Subject: RE: A/25/20/DOC - Arundel Rd - Additional Info - Updated AMS

I can now confirm that condition no.4 can be discharged.

Comments in respect to the outstanding points;

Flexible footway construction (Adjacent Carriageway)

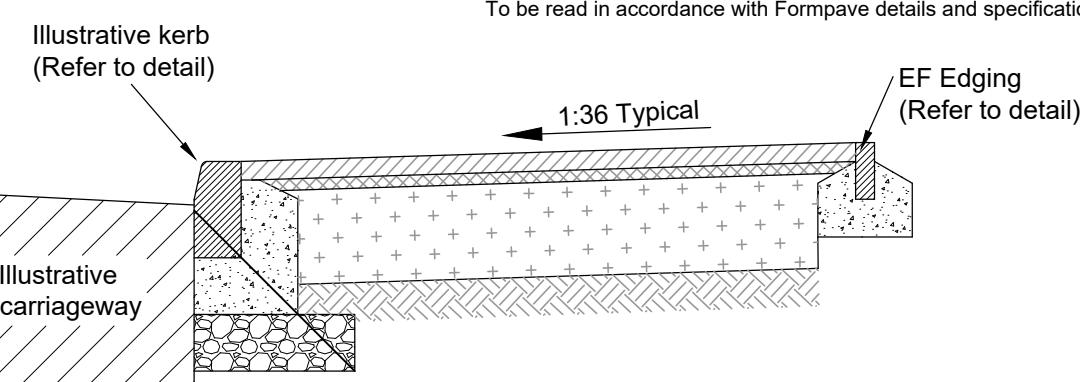
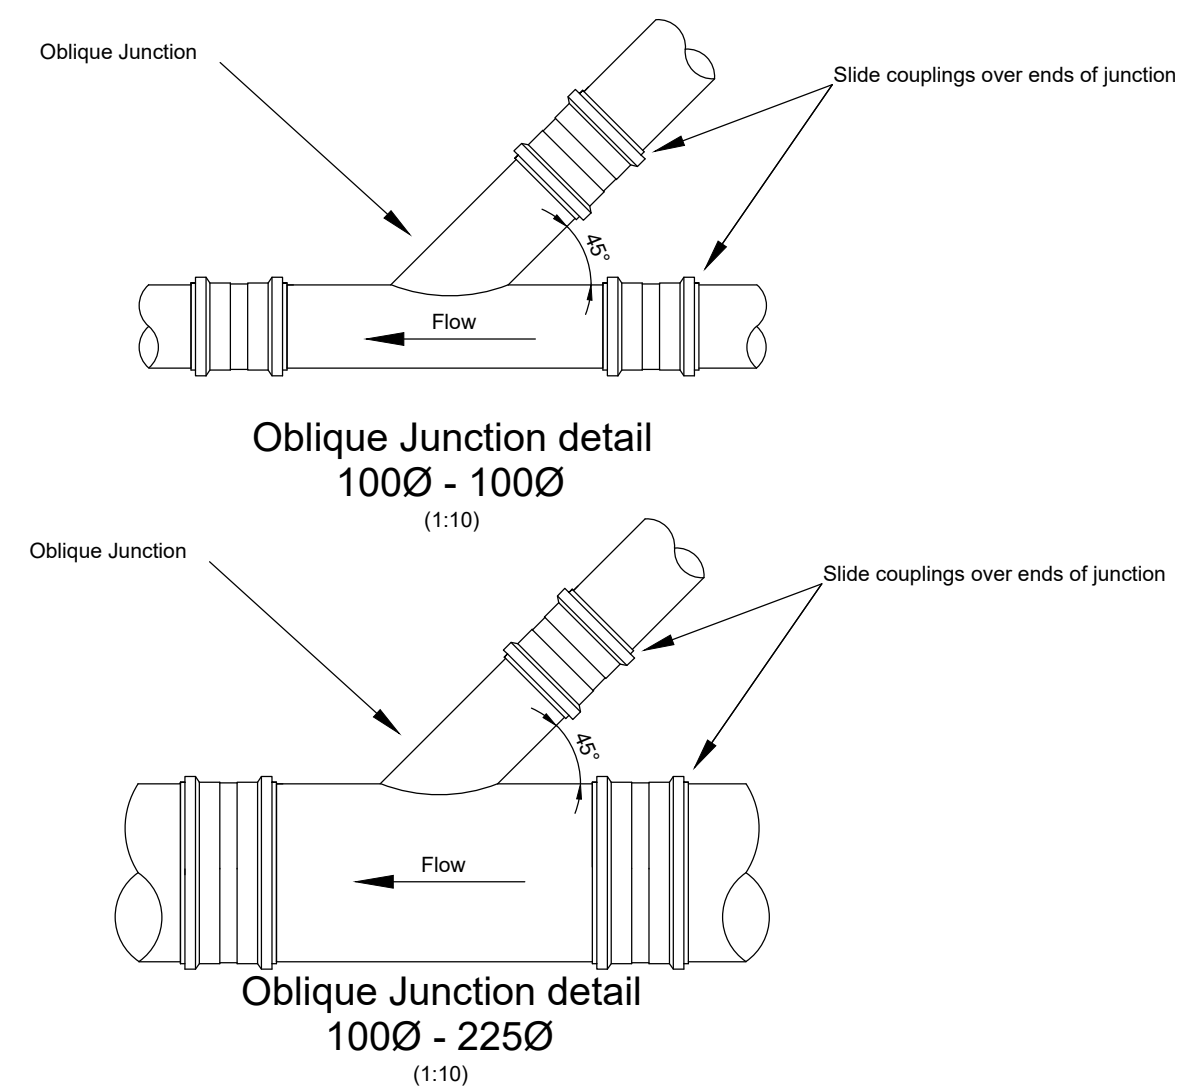
24. No revised drawing supplied – Drawing attached. Sub-bases 250mm.

Formpave permable block paving private driveway construction

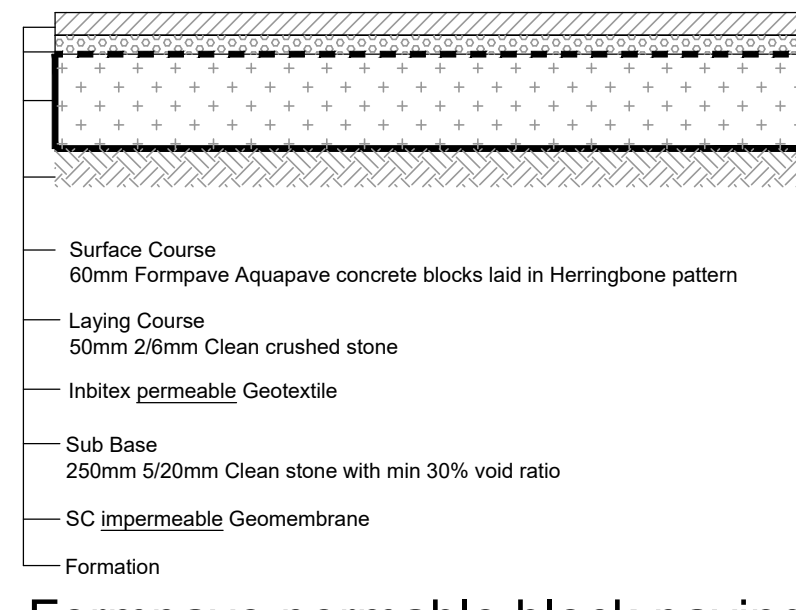
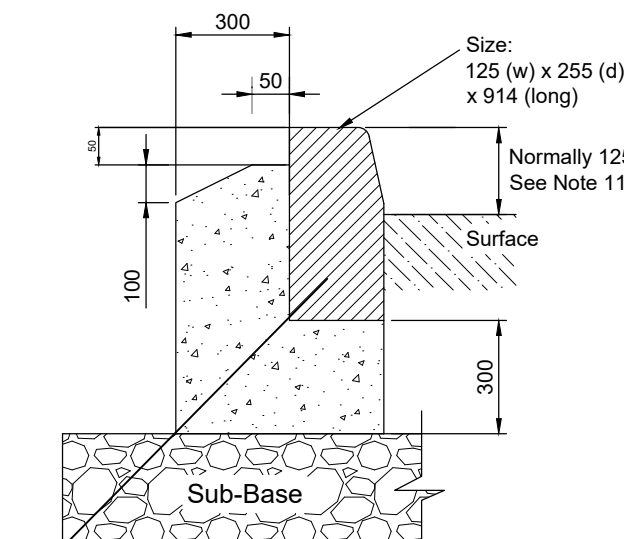
11. I note that the driveway construction has now changed to blockwork. Please make it very clear that the upper layer of inbitex geotextile is porous and the ibitex geomembrane is impermeable – this is for the benefit of the contractor. – Note added onto drainage layout and detail updated to make it clearer.
